I wish to lodge my strong objections to 2020/92209,

Case officer

Adam Walker

Drawing title
 Elevations

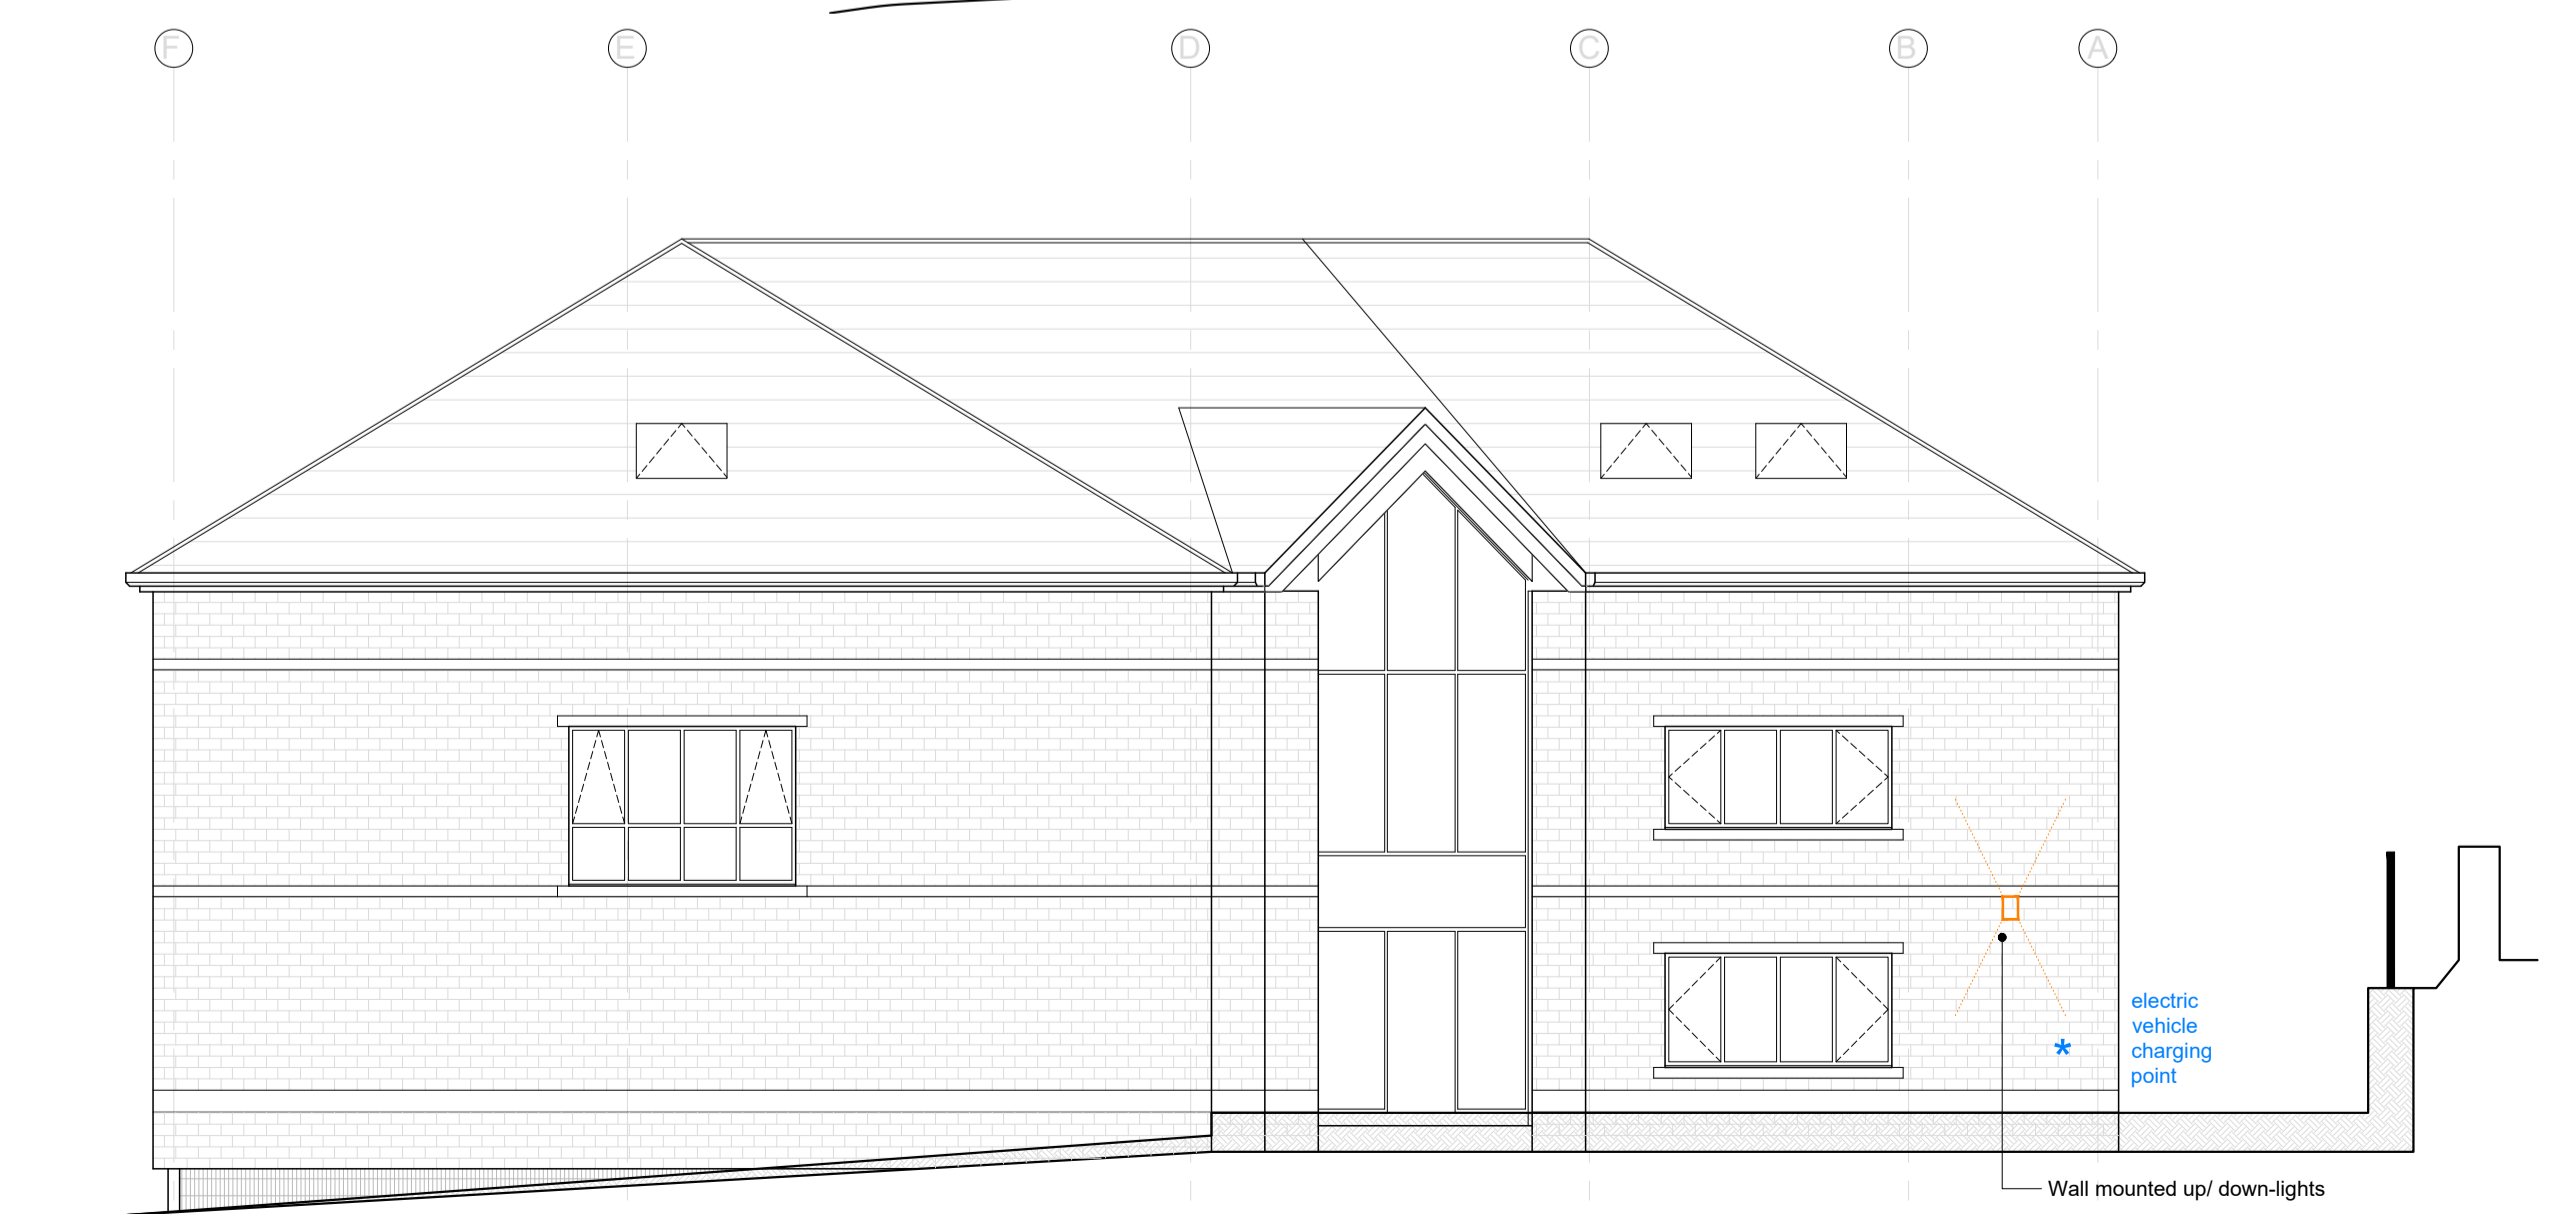
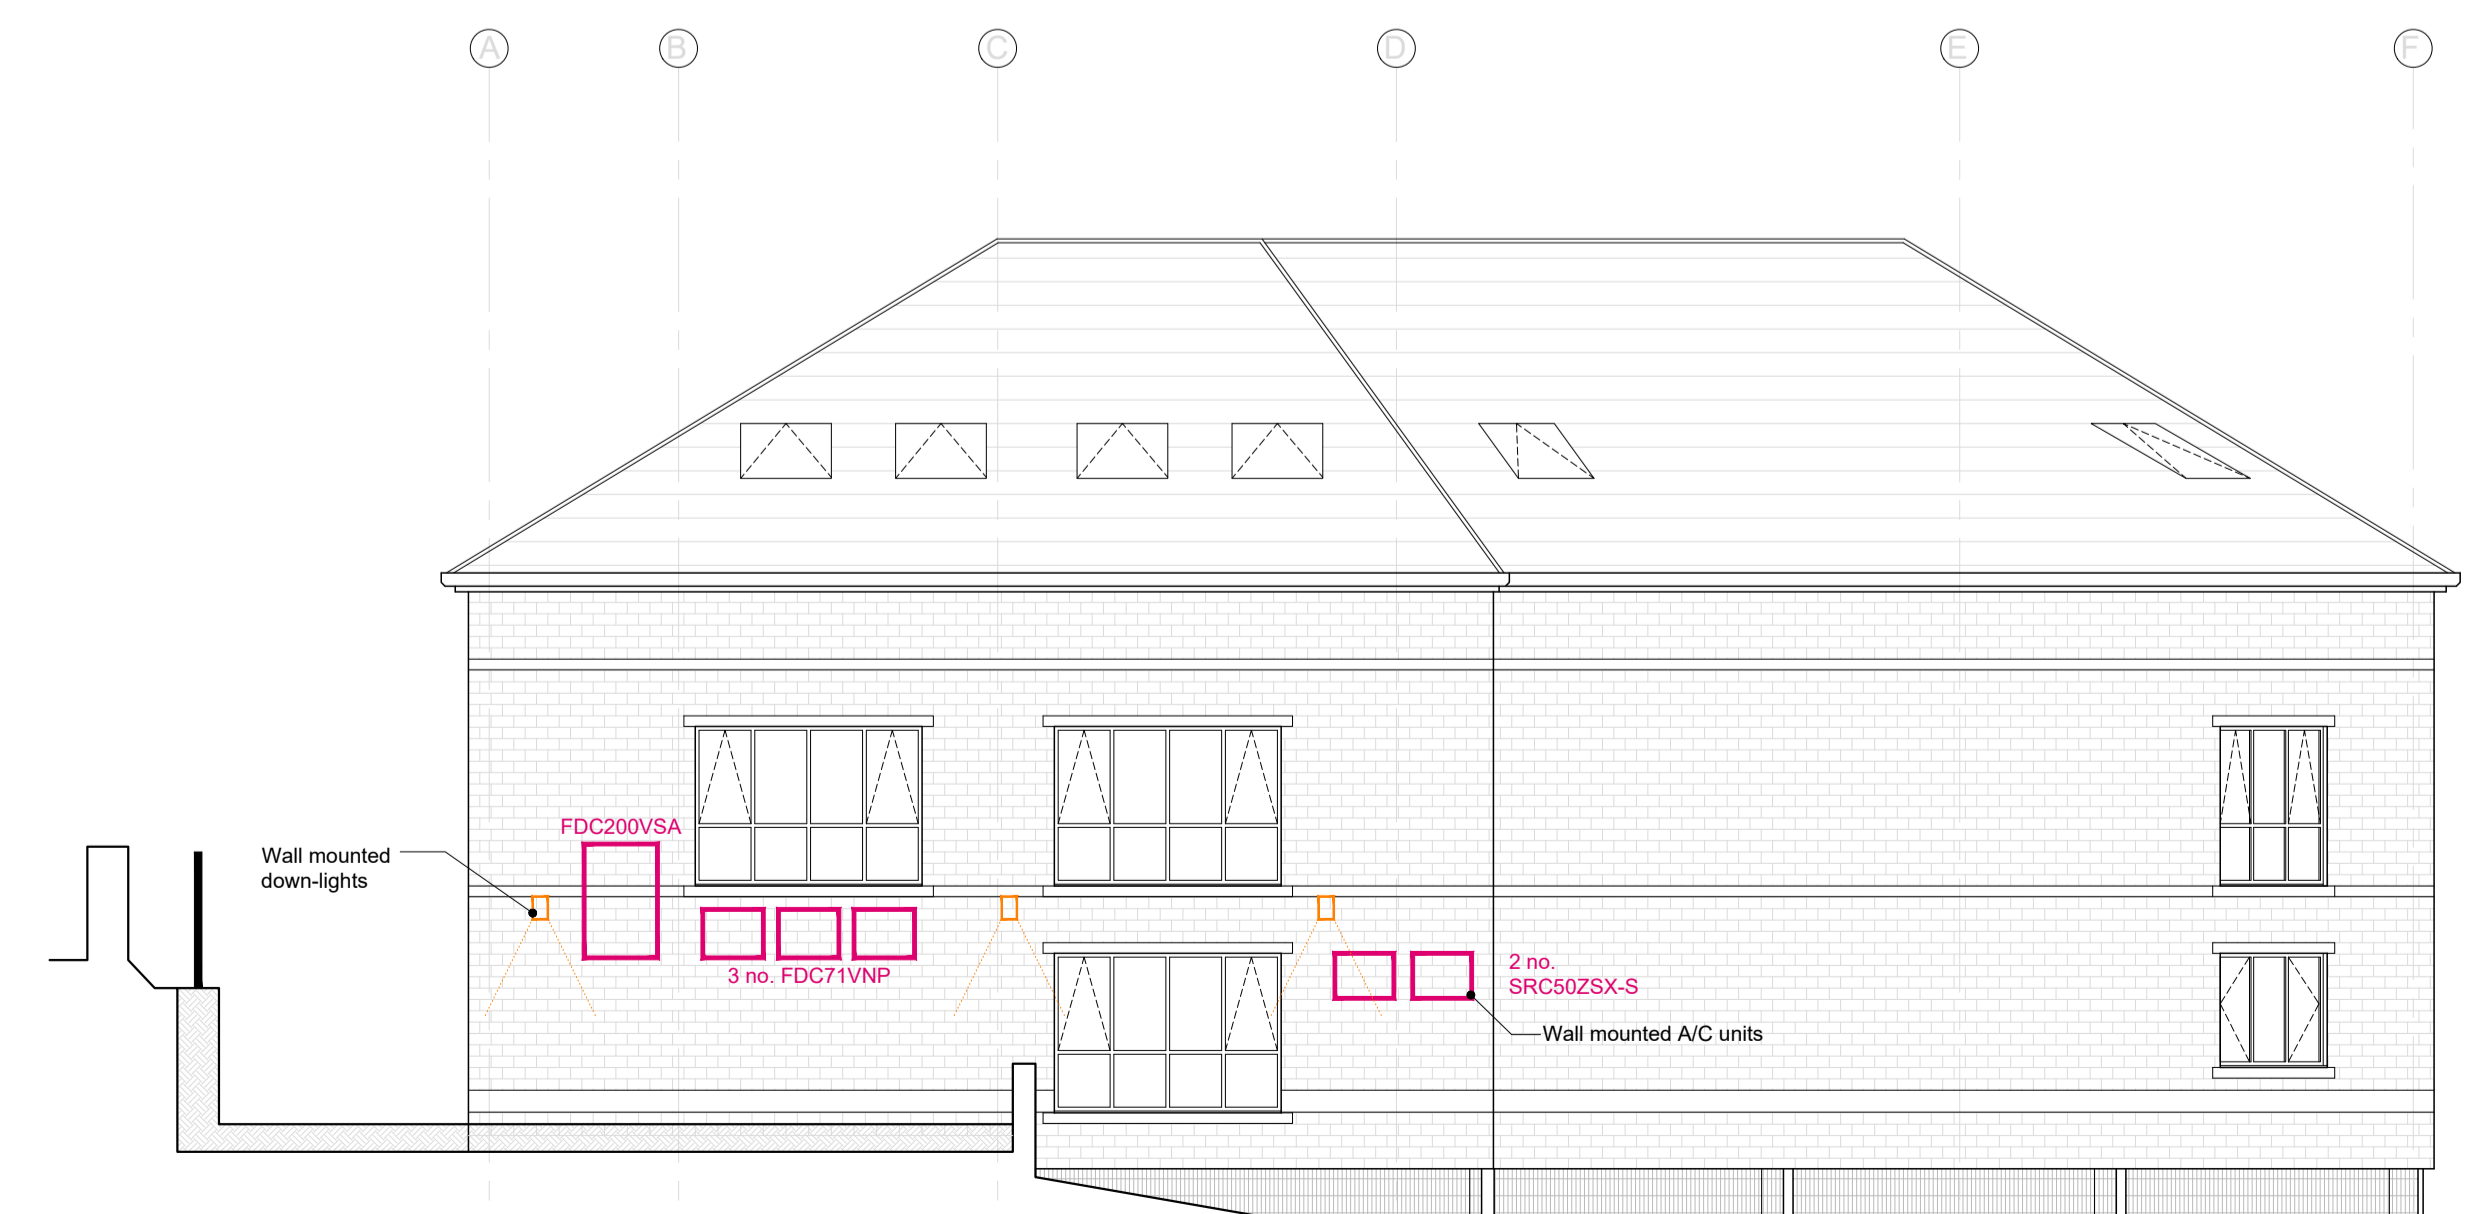
Noise and disturbance resulting from use of the new building: I have carried out acoustic noise calculations (see calculation sheet below) based upon the Air conditioning and Heat pump mechanical plant units installed externally along the Lower Gate side of the new building as specified in the 2020/92209 documentation. My calculations indicate that a noise level of **51 dB(A) at NSR Lower Gate** is predicted based upon the already installed air conditioning and heat pump mechanical plant units' manufacturer's published data

and the location / directivity / distance of the installed mechanical plant to NSR Lower Gate. Allowing a 12db open window loss would give a level of 39 dB(A) inside front upstairs bedroom but that presumes the Lower Gate residents don't make use of their front yards which I know they do. The heat pump is the noisiest unit with a manufacturer's quoted *Sound Pressure level* of 66 dB(A) at 1 metre. Calculating *conformal radiating surface area* at 1m (correction of 15dB) produces 81 dB(A) *L_w Sound Power Level* for Mitsubishi 560KXZE1 Heat pump. All other units published manufacturers data are quoted as Sound Power Levels. Mitsubishi FDC200VSA 74 dB(A)*L_w* single unit (6 installed). Mitsubishi SRC35ZMX-S 63 dB(A) *L_w* single unit (3 installed). The distances vary from unit to unit to NSR but 28 metres has been used as the attenuation distance as this is quoted in the Councils own document attached to planning permission 2017/93366.

The increase in roof height by over a metre and the subtle expansion of the building width via alterations to the curtain walls will in effect undo the attempt to reduce what is already a wholly inappropriate building in this location in terms of scale and mass. This increase in roof height and the expansion of the building width via alterations to the curtain walls and fenestration should not be permitted.

The proposed significant changes to the fenestration and the raising of the overall roof height by in excess of one metre as submitted would adversely impact upon the amenity of residents along Lower Gate and more particularly some of the back-to-back properties to the North along Longwood Road and is unsympathetic in overall mass, character and scale.

The fenestration changes further impact the privacy of neighbouring houses.

The proposal has an excessive number of poorly directed wall lights generating significant light pollution.
